**KIRKLEES METROPOLITAN COUNCIL
INVESTMENT & REGENERATION SERVICE**

**DELEGATED DECISION FOR APPLICATION FOR CERTIFICATE OF
LAWFUL DEVELOPMENT**

Reference no.: 2025/CL/90842/W

Description: Certificate of lawfulness for proposed demolition of
existing garage and erection of replacement garage

Rev	Date	Revision
PROJECT: Proposed Garage 31 Warreside Deighton, Huddersfield HD2 1LW		
CUSTOMER / CLIENT: Graham Dearden		
DRAWING: Plan, Elevations

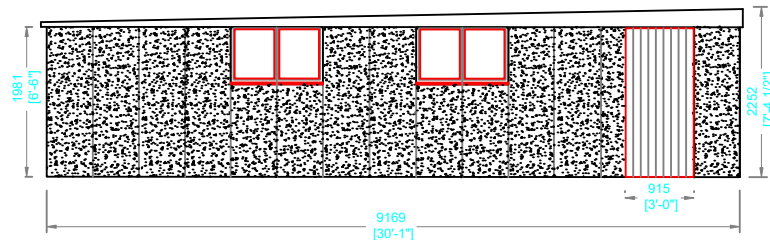
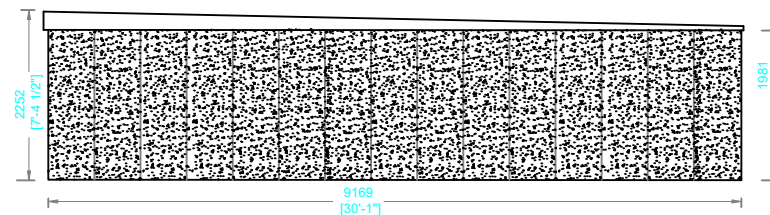
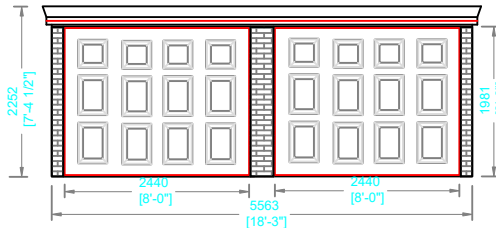
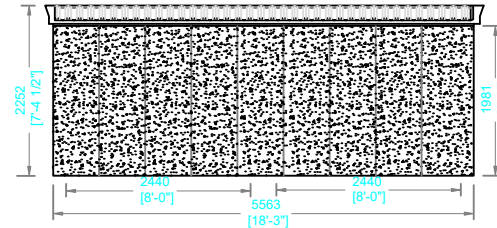
Comment: The proposed outbuilding is shown to be within 2 metres of the boundary and is less than 2.5 metres in height with a flat roof, therefore this requirement is satisfied.

Comment: The height of the eaves of the development would not exceed 2.5m.

title  
Site Plan - As Proposed

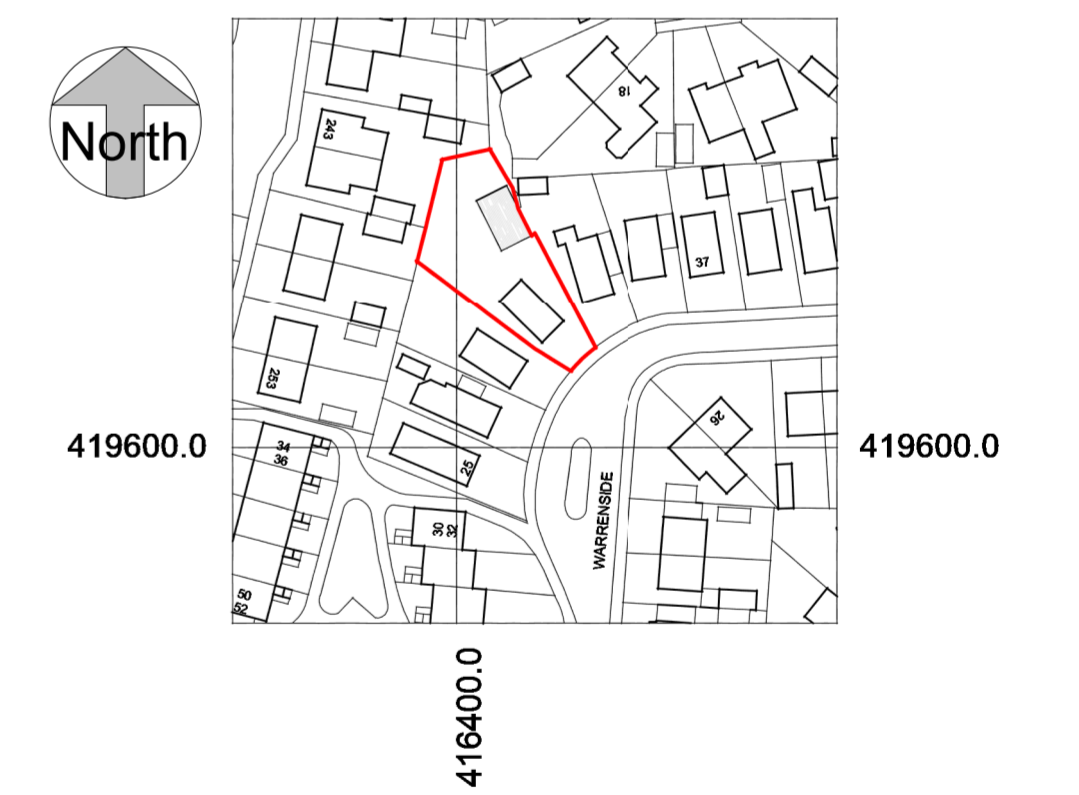
Comment: The outbuilding is not located beyond the principal elevation line of the original dwellinghouse and therefore does satisfy this requirement.
